SSD 10477 – Stage 3 Facilities Sydney Business Park, Marsden Park

ATTACHMENT A

Review of the engineering plans by Orion Consulting for stage 3 Sydney Business park, Project No. 20-0127, Set 02, Rev. A, Dwg. No. 000 to 602, dated 31.07.20 raised the following issues:

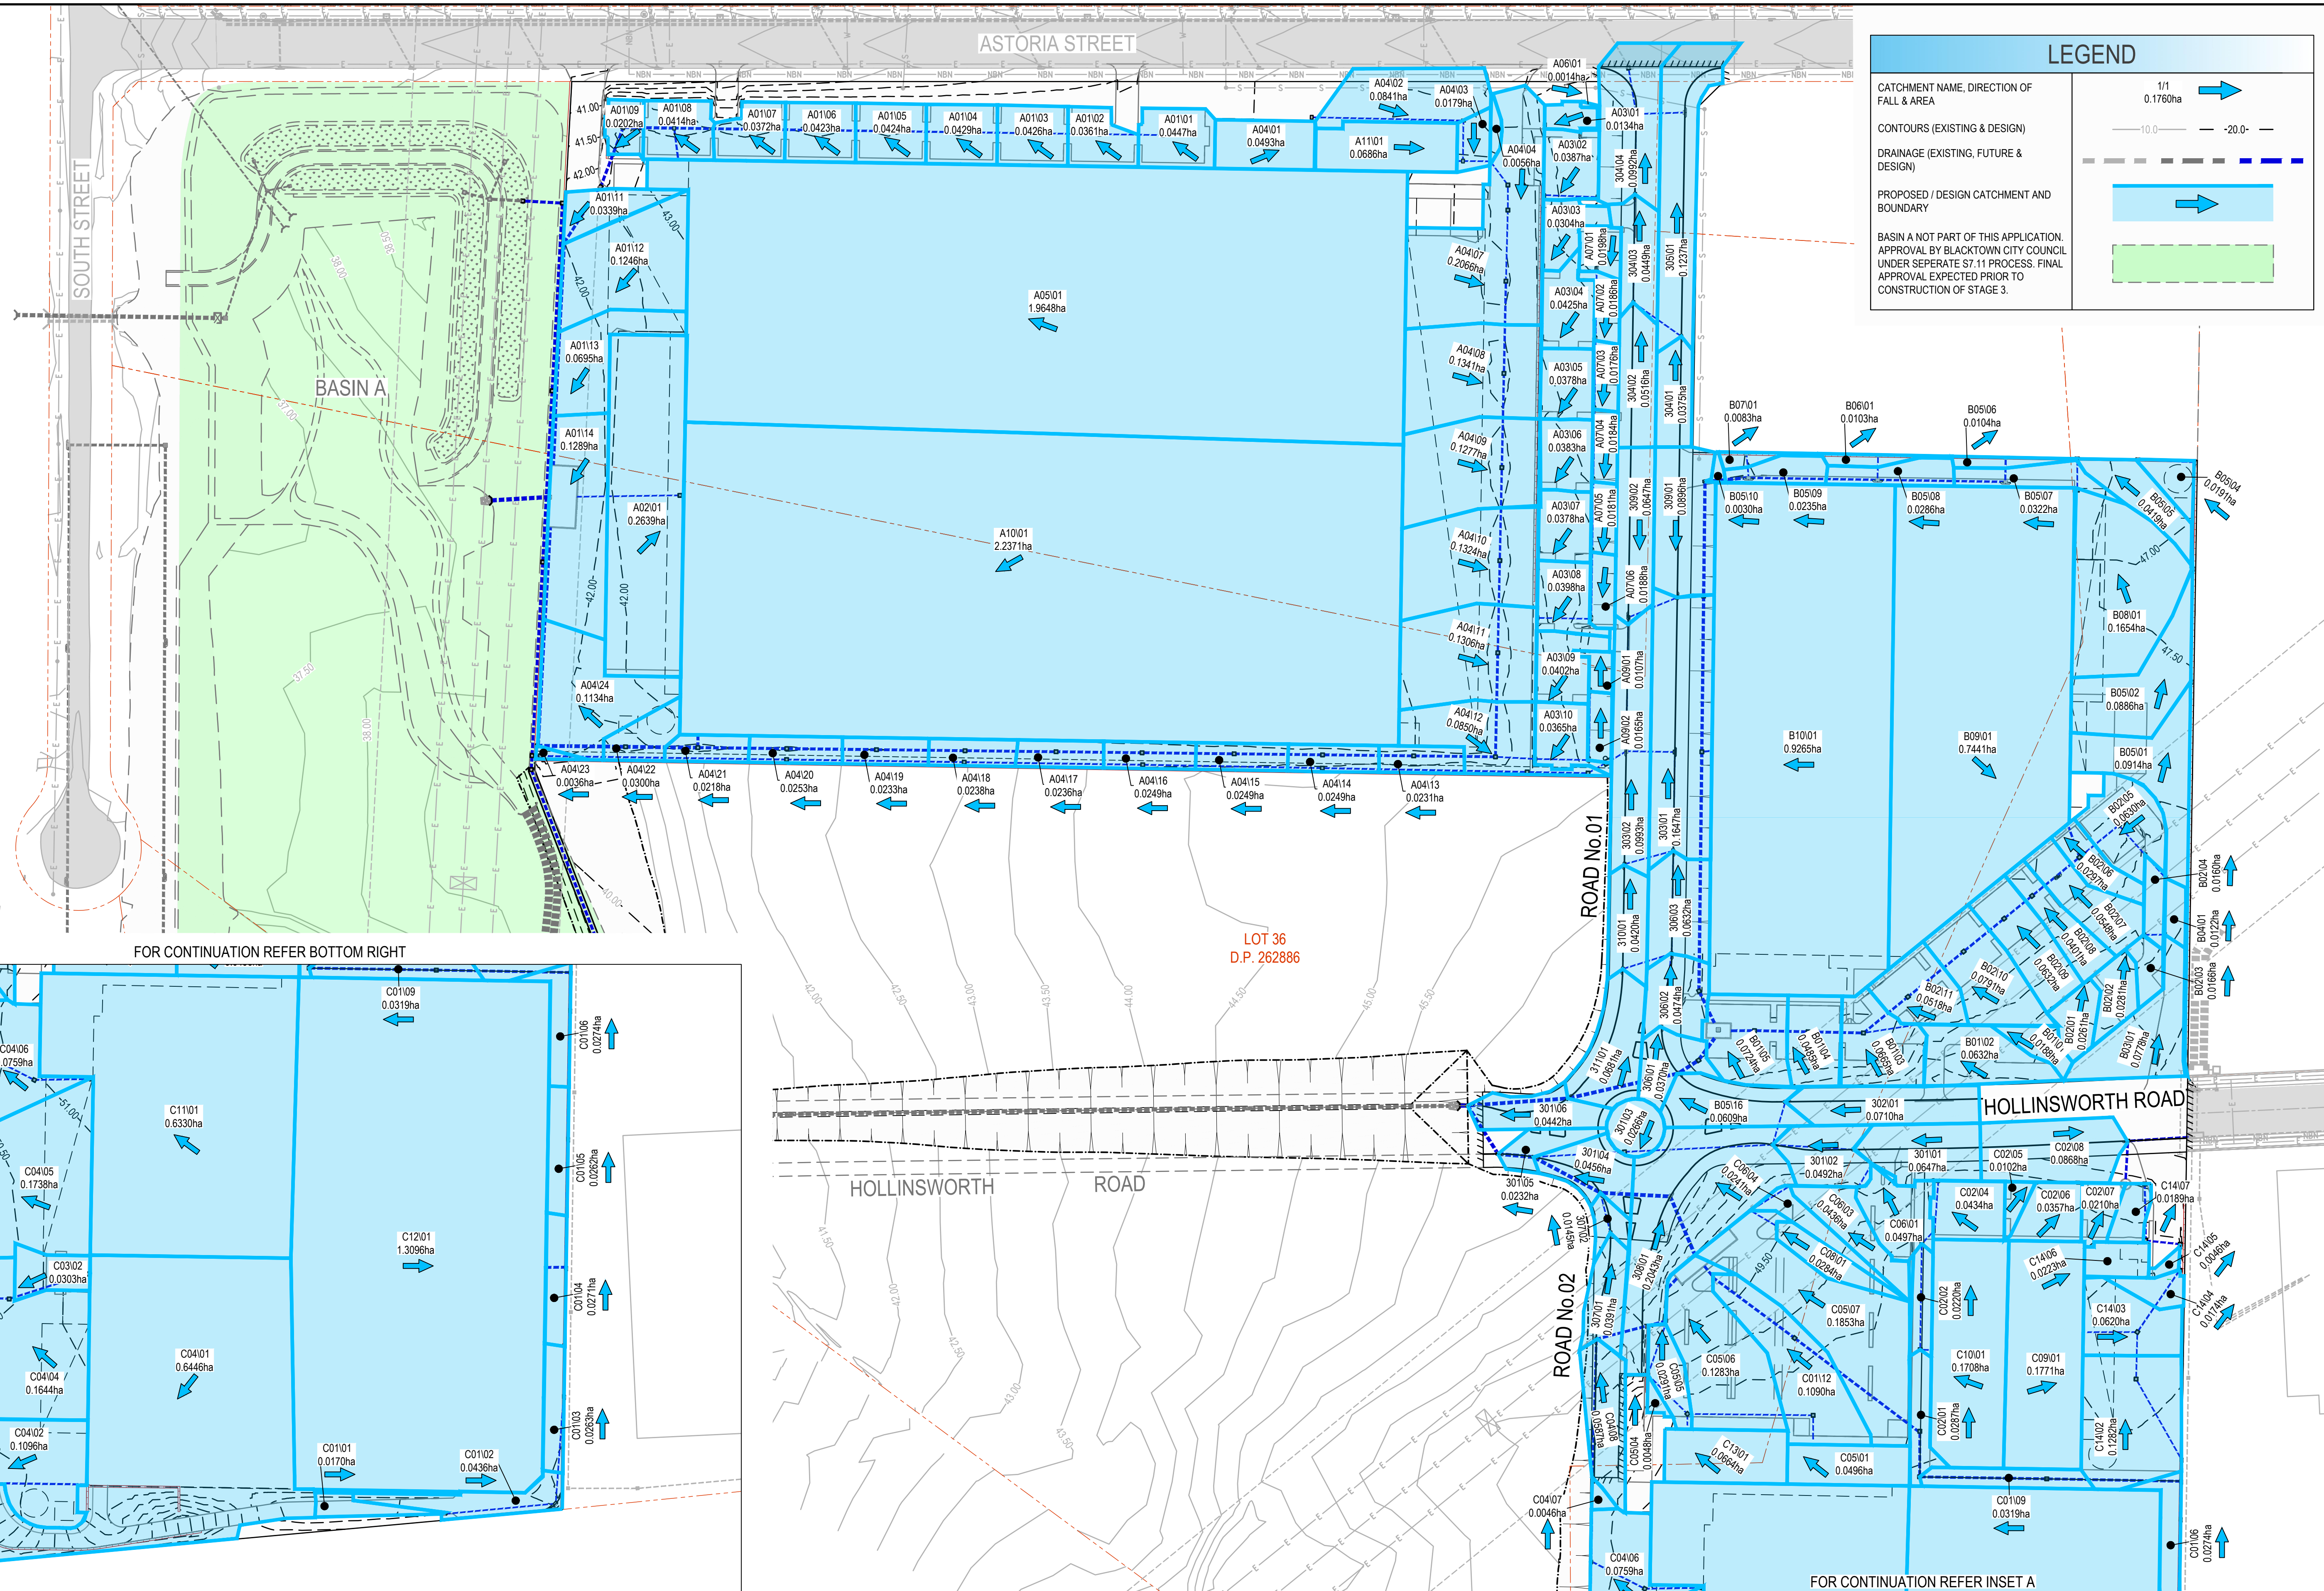
30. Dwg. 204 (A) and 400 (A), most of the south area landscaping and driveway of warehouse 4 is in bypass for both water quality and detention basin. Furthermore, the current contour and spot levels will create ponding in that area. Provide the area as per the stormwater catchment plan.

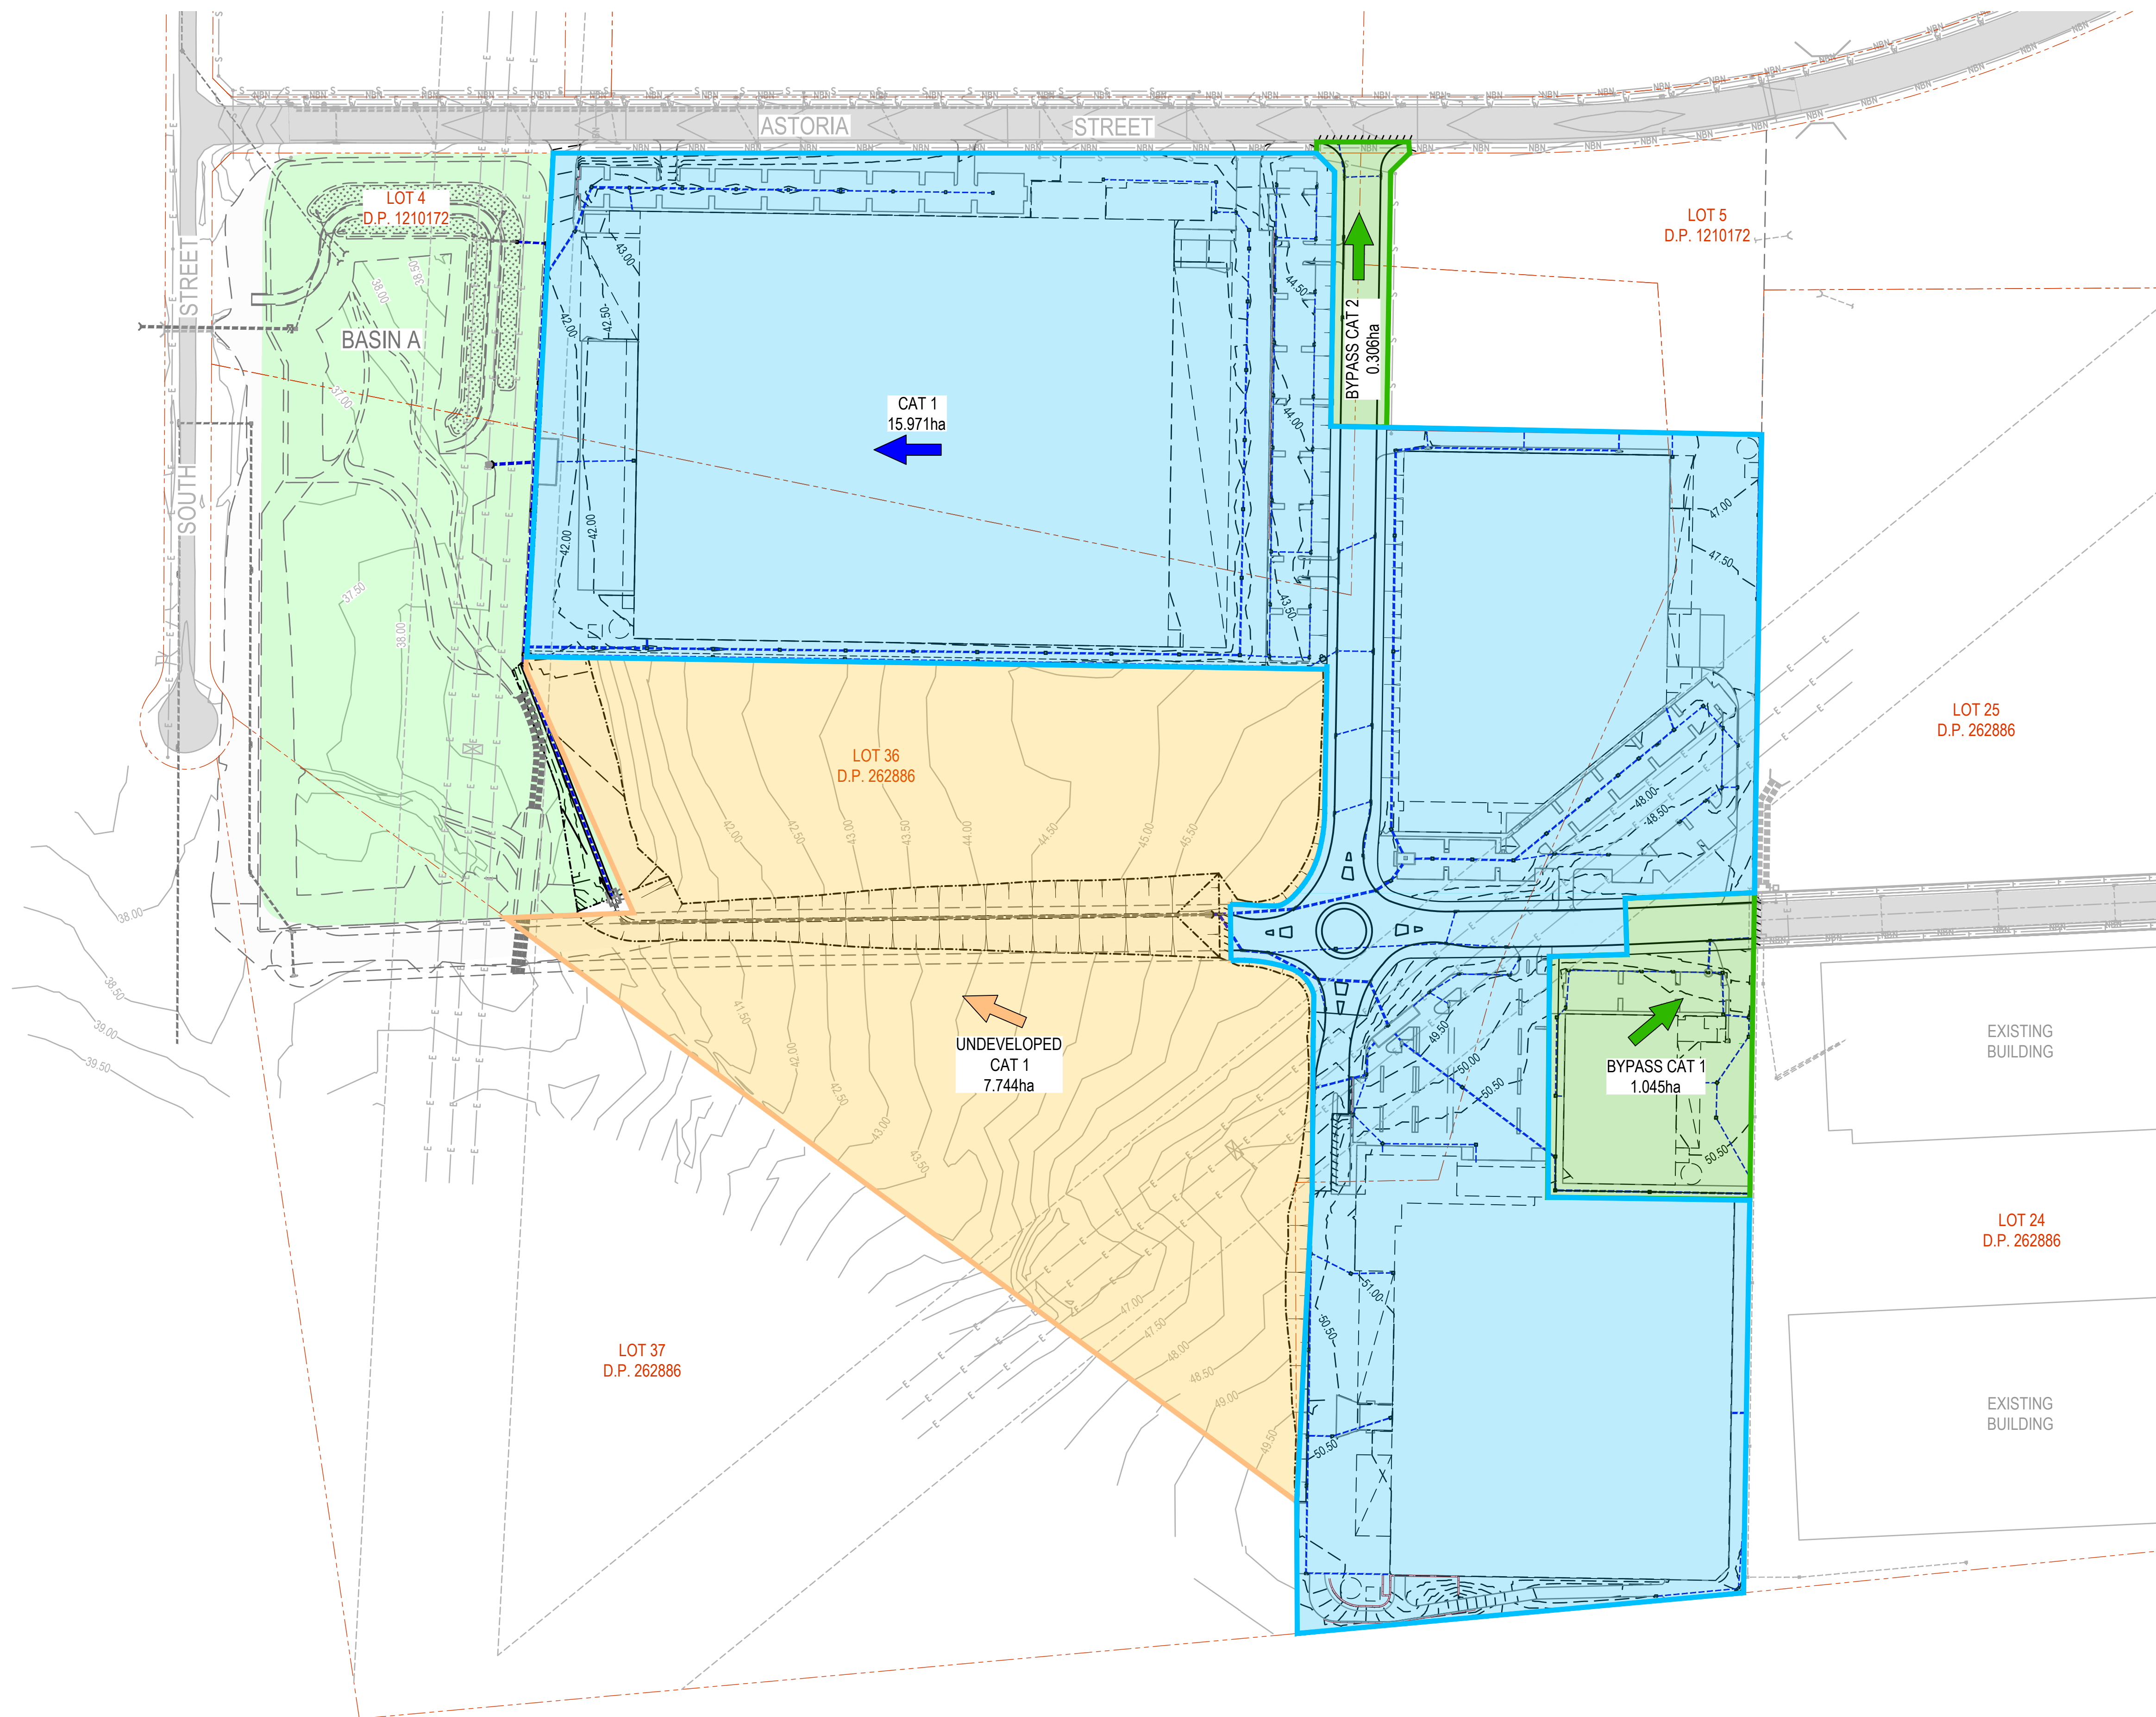
3. Further to the above, it appears the catchment drainage through the proposed easement may be reduced by directing the outlet from the Warehouse 2 treatment tank to pit 306/01, and ultimately connecting this line into pit B05/17.
4. The catchment plan on sheet 401 must divide the western-draining catchment into segments showing the total areas draining through;
 - a. The proposed GPT and subsequent easement (pit 303/03)
 - b. The temporary swale and future Hollinsworth Rd alignment
 - c. Each private filter tank

31. Dwg. 401 (A), batter works to the north of CAT 1 are bypassing detention basin yet they are shown as draining to the detention basin.
32. Provide sufficient and suitable drainage to all recessed docks and design for the 1% AEP storm where it is recessed to eliminate permanent ponding in the area.

40. Dwg. 401 (A): Provide a temporary swale to capture the runoff from the undeveloped catchments. Provide swale sizing and cross sections. The swales are to clearly show how the undeveloped catchment drains to the temporary basin as proposed but not shown.
41. Dwg. 006 (A): provide details of the temporary 1:1 batter, provide a note stating that retaining walls beyond batters of 1:3 (private) are to be to the satisfaction of a geotechnical engineer.
42. On all drainage long sections, state whether the HGL provided is for the 20yr ARI or the 100yr ARI.
43. All pits are to be sealed from pit 301/11 to the ultimate discharge point to avoid any premature surcharging of the 3month flows.
44. Dwg. 413 (A): Provide the downstream IL and details of the existing connection point for the proposed pit 304/05.
